# CITY OF ALBUQUERQUE

August 2, 2022

Re: **AVID HOTEL**  
**1441 Woodard Road SE**  
**Traffic Circulation Layout**  
Architect's Stamp NONE (M15-D023B)

Based upon the information provided in your submittal received 07-27-2022, the above referenced plan cannot be approved for Building Permit until the following comments are addressed:

SP-1

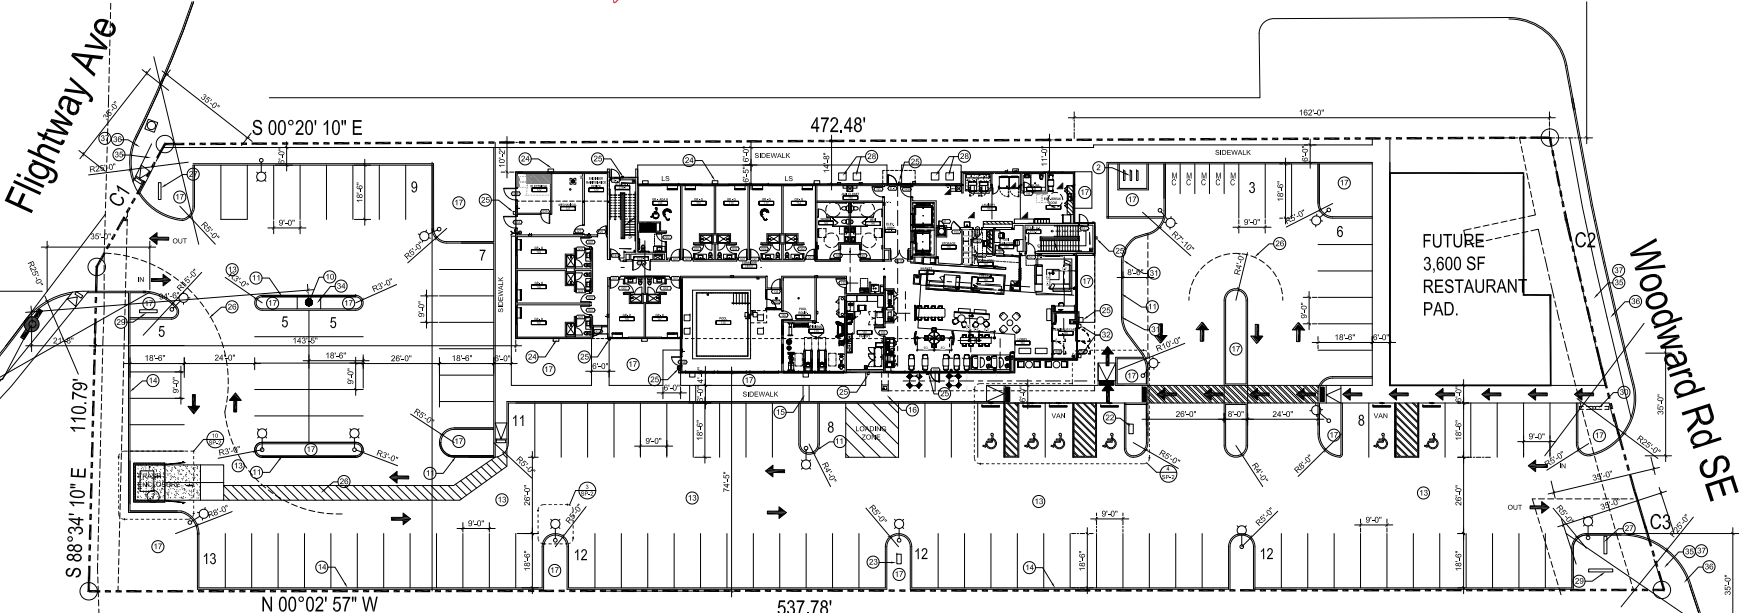
1. Listed are the number of parking spaces required by the IDO as well as the proposed number of parking spaces including bicycle and motorcycle parking. Coordinate/discuss with Zoning. **Shown are the requirements for Hotel but not for Future Restaurant. So, please break down and separate required calculations for Hotel versus Restaurant.**

- Some keyed notes shown on items are incorrect. Please address this concern.
  - **Keyed notes 29 & 30:** Verify that location of proposed signs will not encroach onto COA right of way. This includes airspace.

5. **Woodard/Flightway proposed entrances:**
  - Provide entrance design detail and/or reference COA Std Dwg 2526.
  - Ramp symbols will need to be provide to demonstrate propose ramps with truncated domes.

- **Sidewalk (proposed/existing):** Provide width and details (or reference COA std dwg 2430).
  - **Sidewalk end treatment:** Provide (Note) a 5:1 taper to tie into existing ground surface to avoid tripping hazard at end of sidewalk (if applicable).

6. Identify all existing access easements and rights of way width dimensions (If applicable).
7. Identify the right of way width, medians, curb cuts, and street widths on Woodard and Flightway.
8. Please list the width and length for all proposed parking spaces. Some dimensions are not shown.
9. The minimum parking stall dimensions are:

10. The ADA accessible spaces must include an access aisle. Van accessible aisles should be 8ft wide; all others should be 5ft wide.
11. The ADA accessible parking sign must have the required language per 66-7-352.4C NMSA 1978 **"Violators Are Subject to a Fine and/or Towing."** Please call out detail and location of signs.

12. The ADA access aisles shall have the words **"NO PARKING"** in capital letters, each of which shall be at least one foot high and at least two inches wide, placed at the rear of the parking space so as to be close to where an adjacent vehicle's rear tire would be placed. (66-1-4.1.B NMSA 1978).

19. Show all drive aisle widths and radii. Some dimensions are not shown.
20. All radii's for curves shown, for passenger vehicles, will need to be 15 feet. Radius for delivery trucks, fire trucks, etc. is 25 ft. or large

21. Per the DPM, a 6 ft. wide ADA accessible pedestrian pathway is required from the public sidewalk to the building entrances. **Please clearly show this pathway and provide details.**

22. Per DPM, a 6 ft. wide ADA accessible pedestrian pathway is required from the ADA parking stall access aisles to the building entrances. **Please clearly show this pathway and provide details.**

26. A hard driving surface will be required as part of this proposed project for parking area and drive aisles. **Please provide thickness of proposed asphalt surface for site.**

27. Please provide a sight distance exhibit and proposed entrances and dimension them appropriately.
28. Show the clear sight triangle and add the following note to the plan: "Landscaping and signage will not interfere with clear sight requirements. Therefore, signs, walls, trees, and shrubbery between 3 and 8 feet tall (as measured from the gutter pan) will not be acceptable in the clear sight triangle. **Sight triangle Not properly shown on site plan.**

29. Please specify the City Standard Drawing Number when applicable.
30. Add a note stating "All broken or cracked sidewalk must be replaced with sidewalk and curb & gutter." A build note must be provided referring to the appropriate City Standard drawing (2430 & 2415A).
